Barnsley Metropolitan Borough Council
Head of Planning

Our ref : 153625-001

Planning Application reference 2025/0161 – Proposed mixed use scheme consisting of: Conversion of Grade II listed Coal Drops into Class E retail; new build extension to Coal Drops with Class E restaurant unit; Conversion of existing Regency House into Air BnB unit; and new build office and light industrial units (Class E) at Penistone Coal Drops, Regency House, Land at St Mary's Street, Penistone, Sheffield, S36 6DT

Drawing Number
27845 A(01) 02 P02

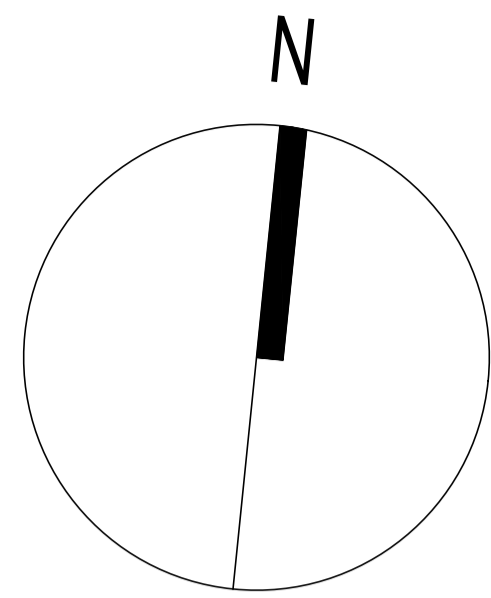
In addition, the layout of the parking areas raises further issues. When scaled, individual spaces appear to fall slightly below the minimum 5.0m x 2.5m dimensions, and several bays may prove difficult to access and manoeuvre within. In particular, the longitudinal bays along the site frontage are likely to require reversing out of the site or complex turning movements within the site, both of which are undesirable.

Cycle parking provision also appears inadequate, particularly given the site’s intention to attract users of the Trans Pennine Trail and the limited vehicle parking proposed. A greater quantity of secure, accessible cycle storage should be provided.

Through liaison with Axis Architecture, cycle parking provision has been increased across the site. This is demonstrated on Drawings 27845_A(01)02_P03 (proposed site plan) and Drawing 27845_A(02)04-P02 (Coal Drops - upper ground floor), attached at **Appendix E**, and includes the following:-
